# **OXFORDSHIRE COUNTY COUNCIL'S RESPONSE TO CONSULTATION ON THE FOLLOWING DEVELOPMENT PROPOSAL**

**Application no:** 16/01545/F

**Proposal:** Change of use of Building 103 to A Heritage Centre (Use Class D1) and Building 315 for storage and distribution (Use Class B8) and associated works.

**Location:** 103 & 315 Heyford Park Camp Road Upper Heyford Bicester OX25 5HA

HEYF-5-SK280

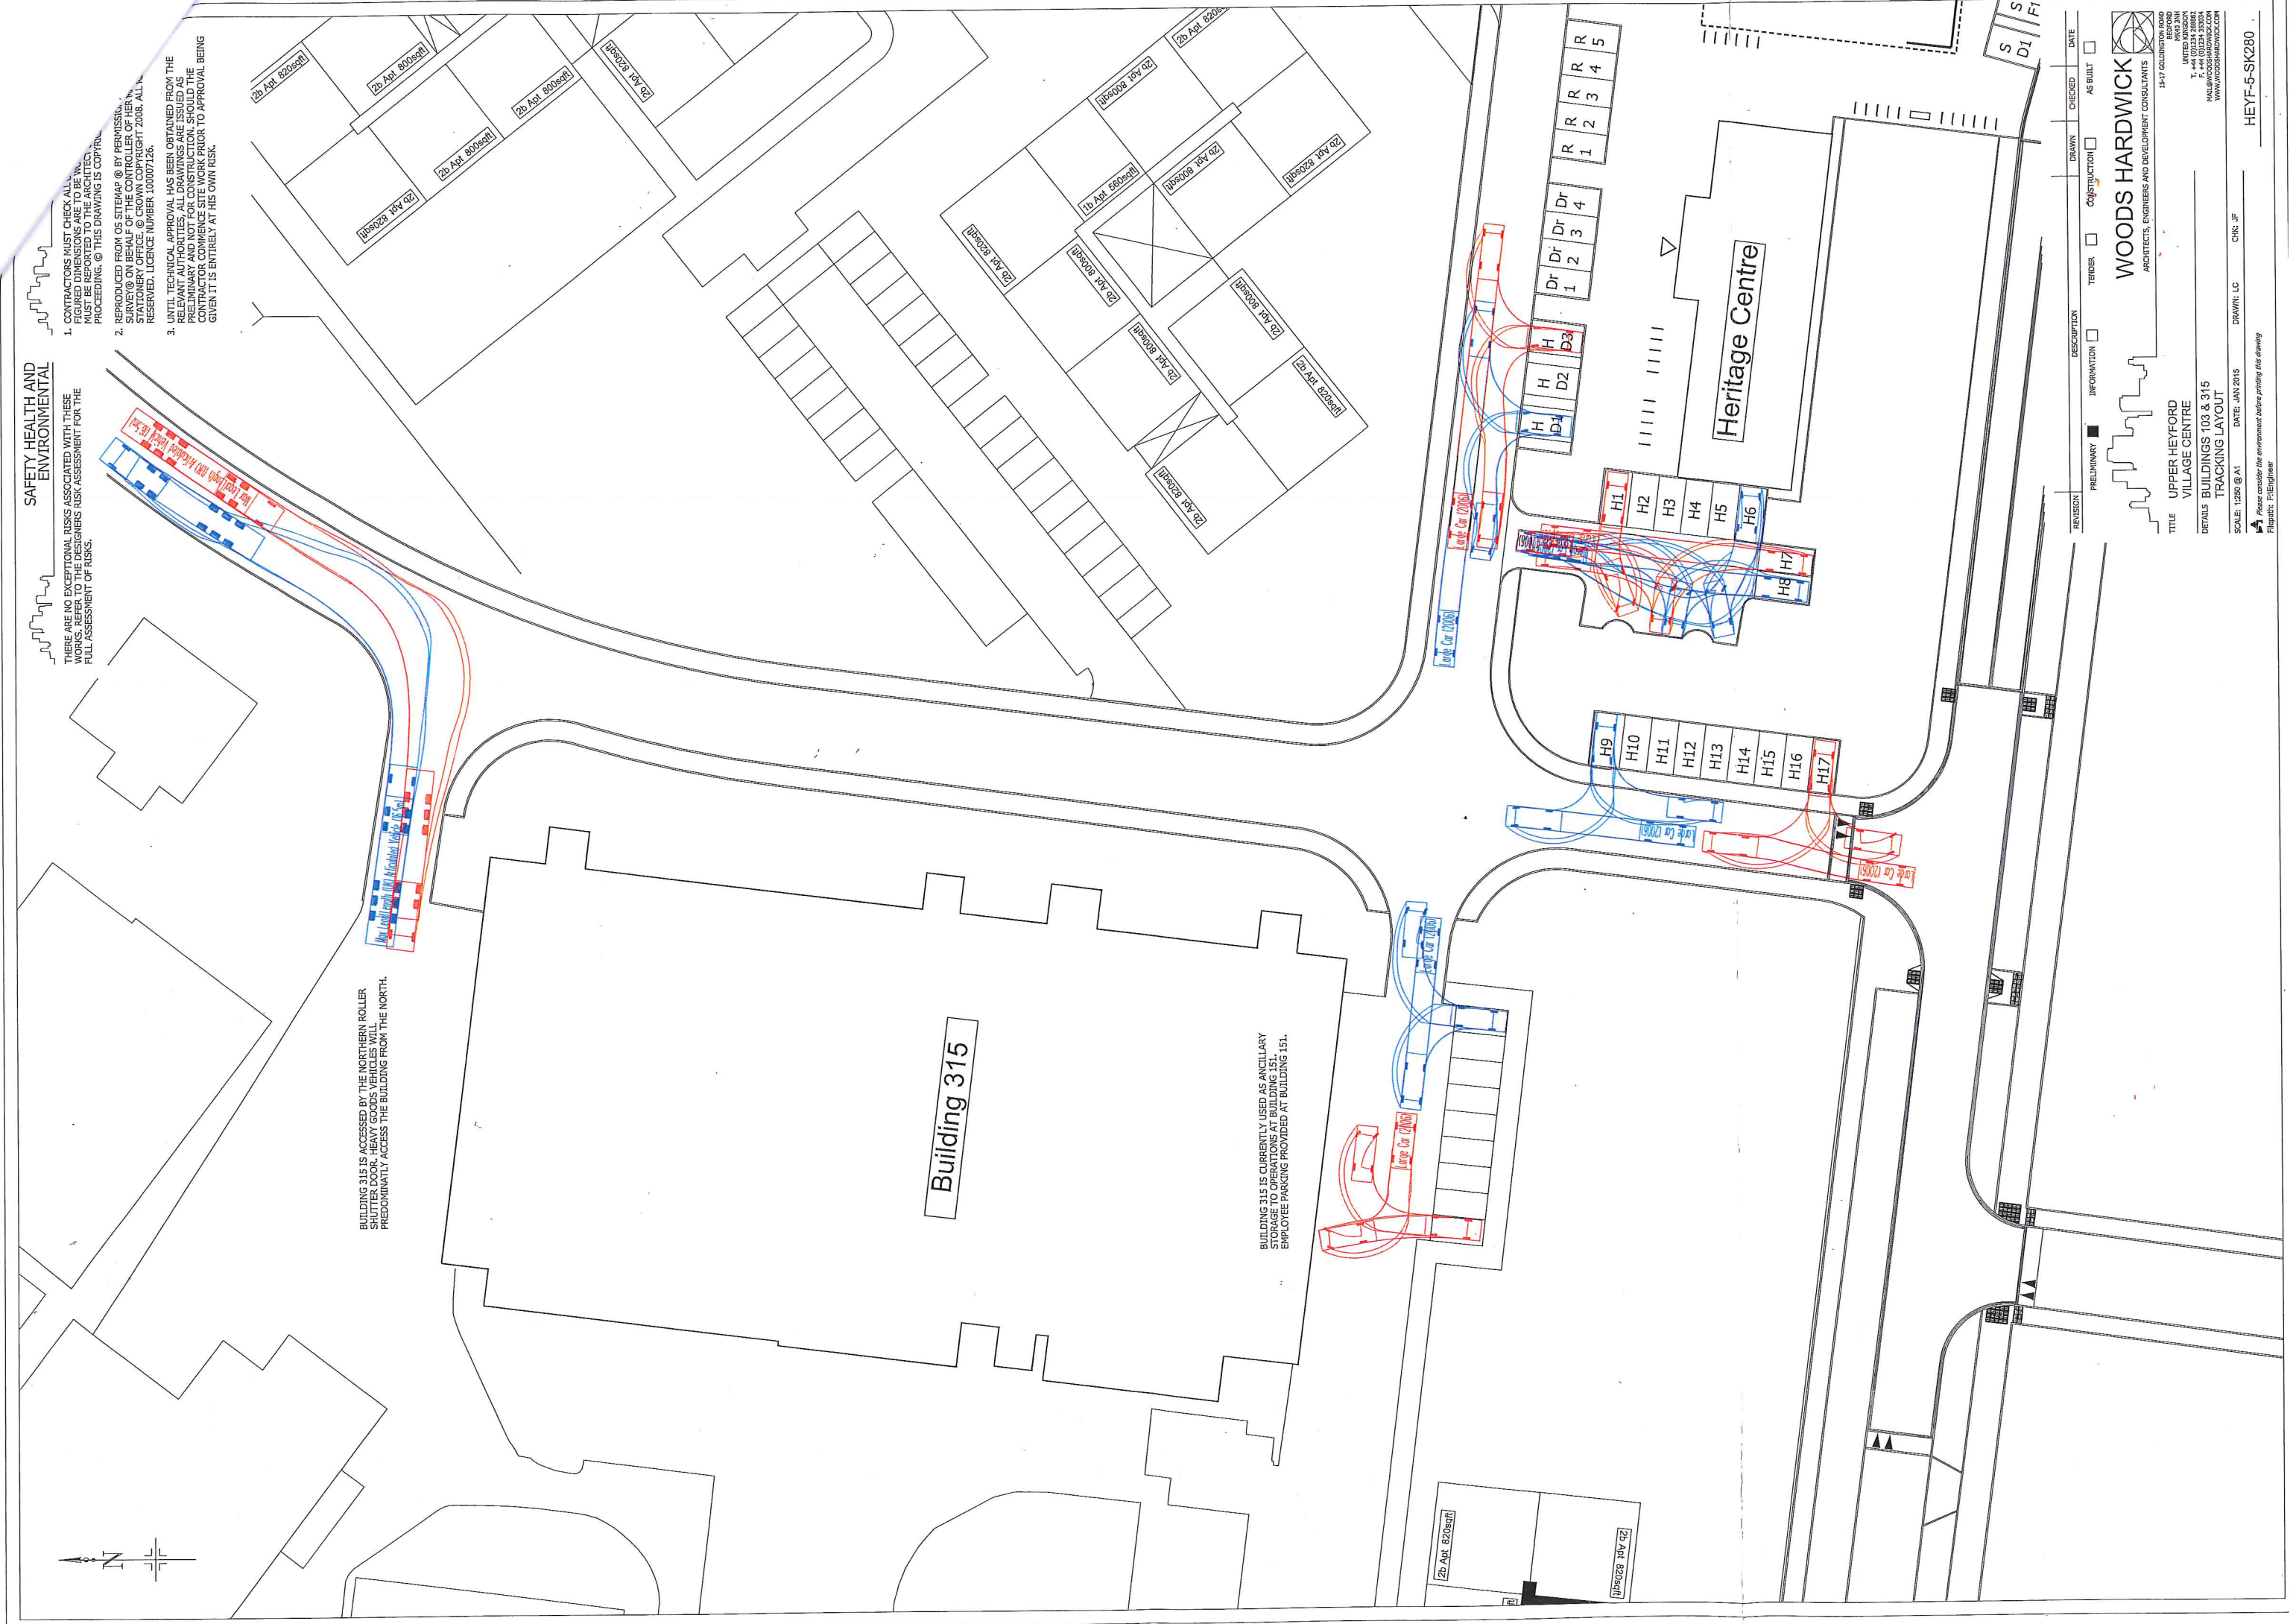
Vehicular access is proposed via the main entrance to Heyford Park via Camp Road. However Drawings **HEYF-5-SK280**, **HEYF-5-SK281** and **D.0341\_107** accompanying this application appear to suggest an access off Camp Road west of the Heritage site. The application suggests that a further access may be available in the future to the west of the Heritage Centre as development of Heyford Park evolves. Whilst this is not yet implemented, all proposals herein should refer to the existing road network including accesses.

This ambiguity needs to be addressed by showing that the link road west of Building 103 is currently a no-through road in the layout drawings.

The proposed parking layout is unacceptable. The perpendicular parking bays behind footways is not considered safe in terms of pedestrian safety and a risk of conflict with other road users. These are denoted by H9-H17 to the west of the Heritage Centre. Perpendicular parking north of the Heritage Centre is also deemed unsafe as it is assumed that parking related movements here would interfere with the movement of traffic along these roads as well as safety of road users. It should also be borne in mind that the roads surrounding the site will be heavily trafficked and shall also be used by buses serving the wider Heyford Park.

I have noticed that the 9 parking spaces south of Building 315 and the 12 spaces north of the Heritage Centre as shown by drawing no **HEYF-5-SK280** are outside of the application site area. The parking that lies outside of the redline application area shall not be taken into account in this assessment until such a time that the applicant demonstrates ownership of this area.

From the same drawing it can also be seen that some parking spaces provided are of insufficient dimensions. Some bays along the access road are shown to have 2.3m widths which is below the required OCC parking standards. The minimum standard dimensions for a parking space as required by OCC are 2.4 x 4.8m.

Drawing No. **HEYF-5-SK280** shows the site layout and tracking in relation to building 103 for a car and building 315 for a 16.5m articulate lorry. Tracking for a car appears very tight in some parking bays which shall not be acceptable particularly those areas along the access road.

It is unclear whether the area marked for vehicle manoeuvring associated with Building 315 is sufficient for HGV's. This needs to be demonstrated with scaled plans that track the swept path of a HGV lorry entering, turning around and exiting the site in forward gear.
